# Consultee Comment for planning application 6/2018/1082/COND

| <b>Location</b>           | <input type="text" value="37 Broadwater Road Welwyn Garden City AL7 3AX"/>  |
| <b>Proposal</b>           | <input type="text" value="Submission of details pursuant to condition 2 (hard and soft landscaping), condition 5 (construction management plan), condition 6 (bin store details) and 8 (noise levels) on planning permission 6/2016/2497/MAJ, dated 16/05/2017"/> |

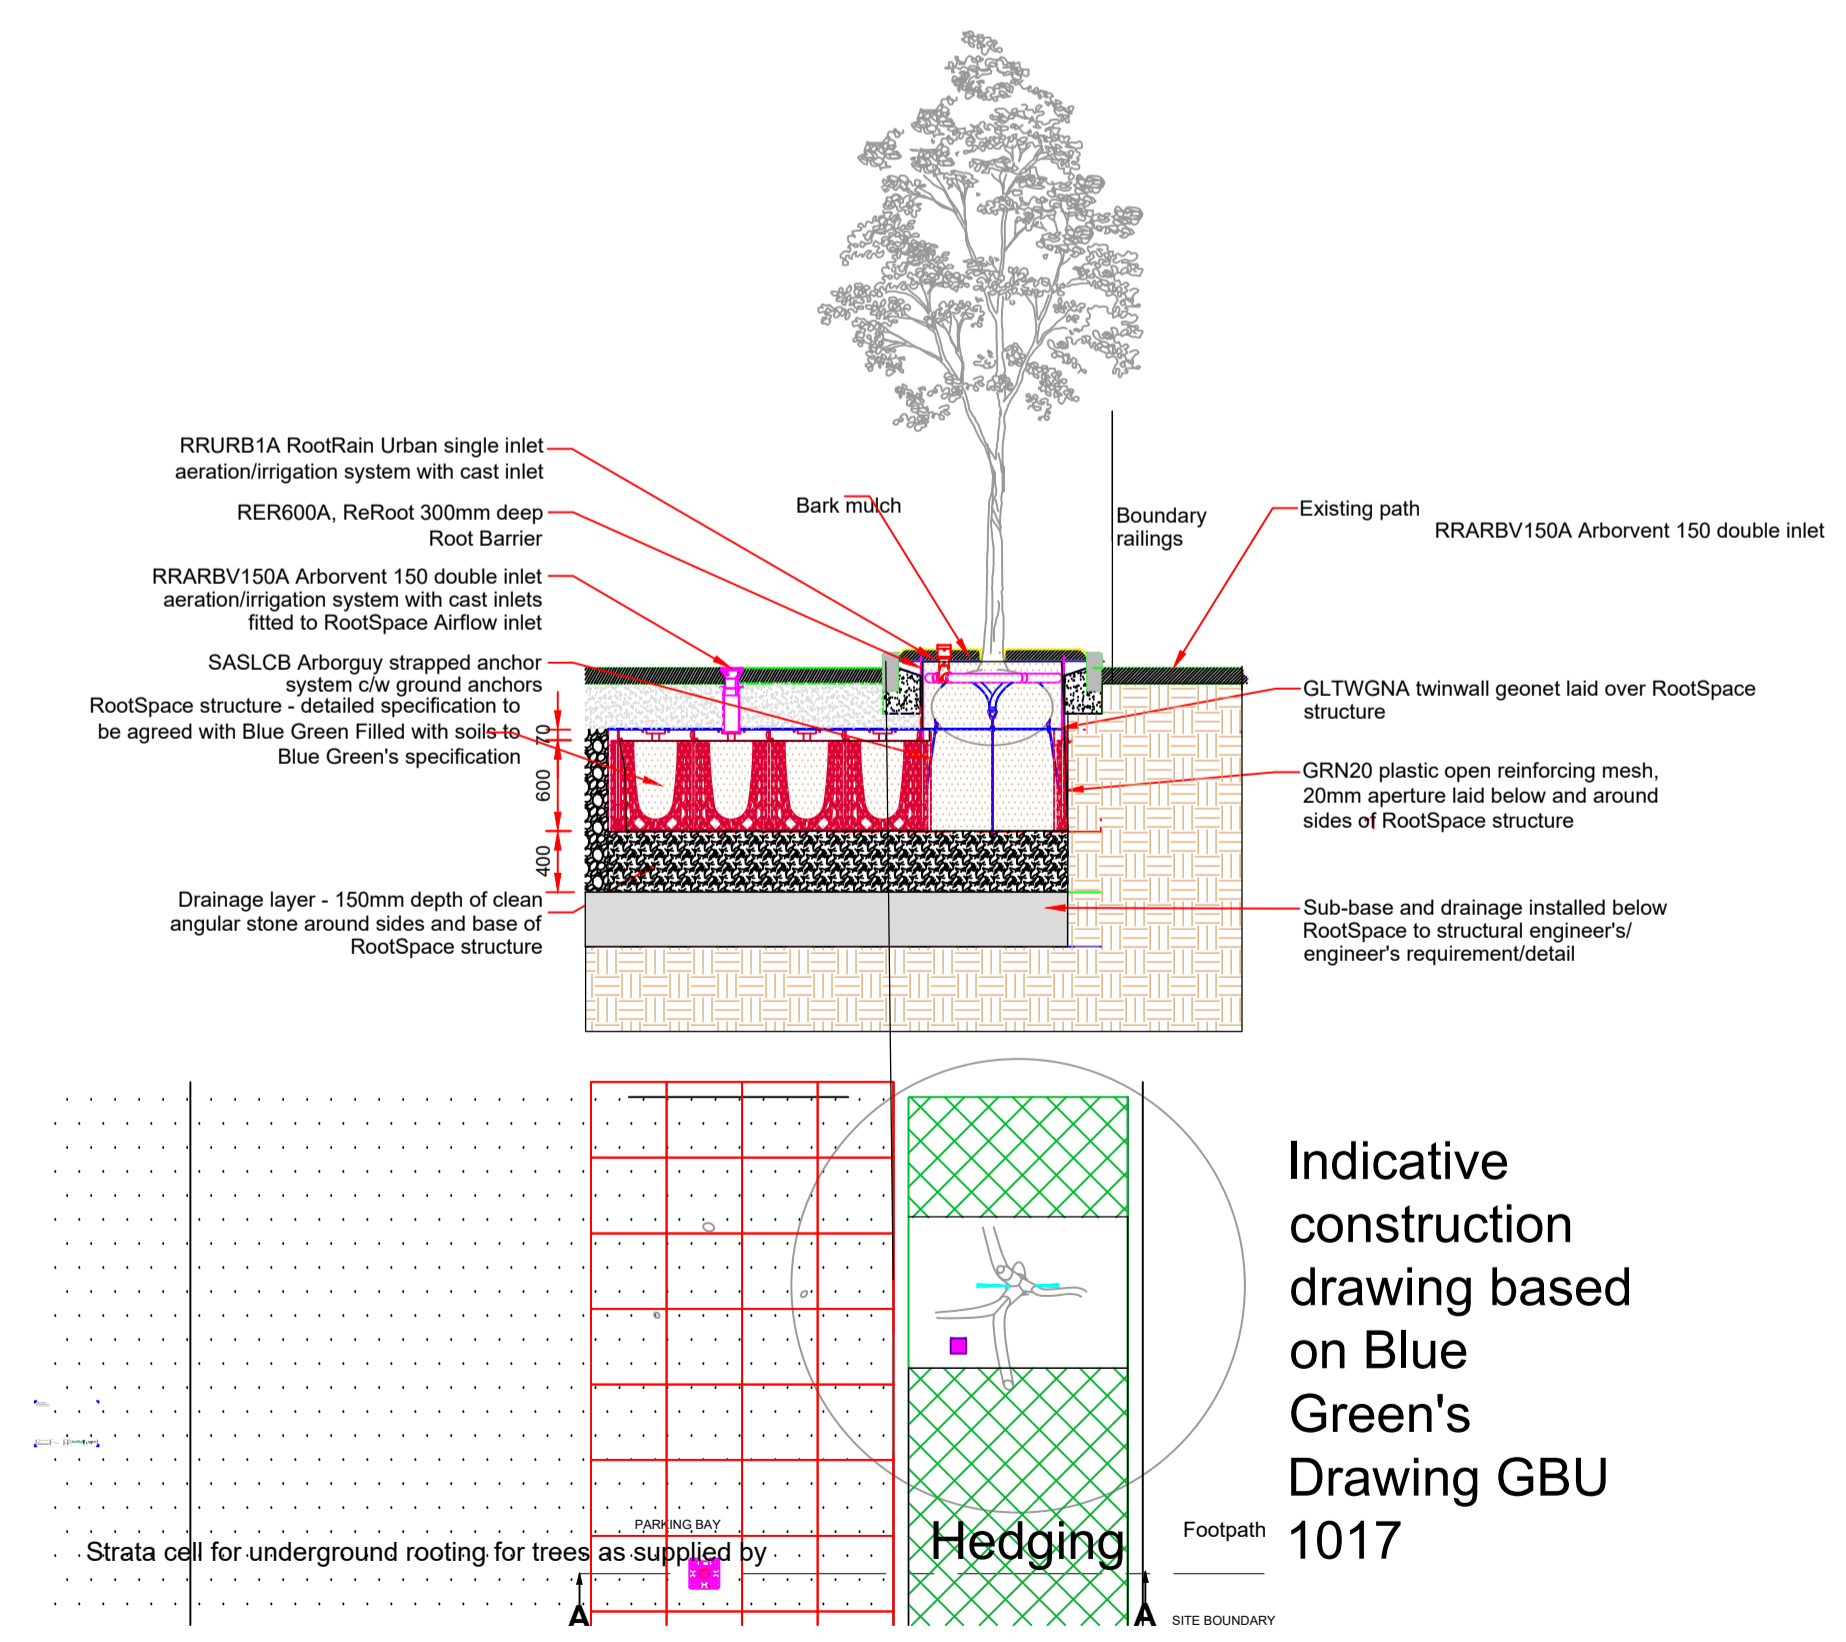
| <b>Comments</b>           | <input type="text" value="I would like to know what species of tree are to be planted under revision c. These should be in keeping with the protected trees."/>   |
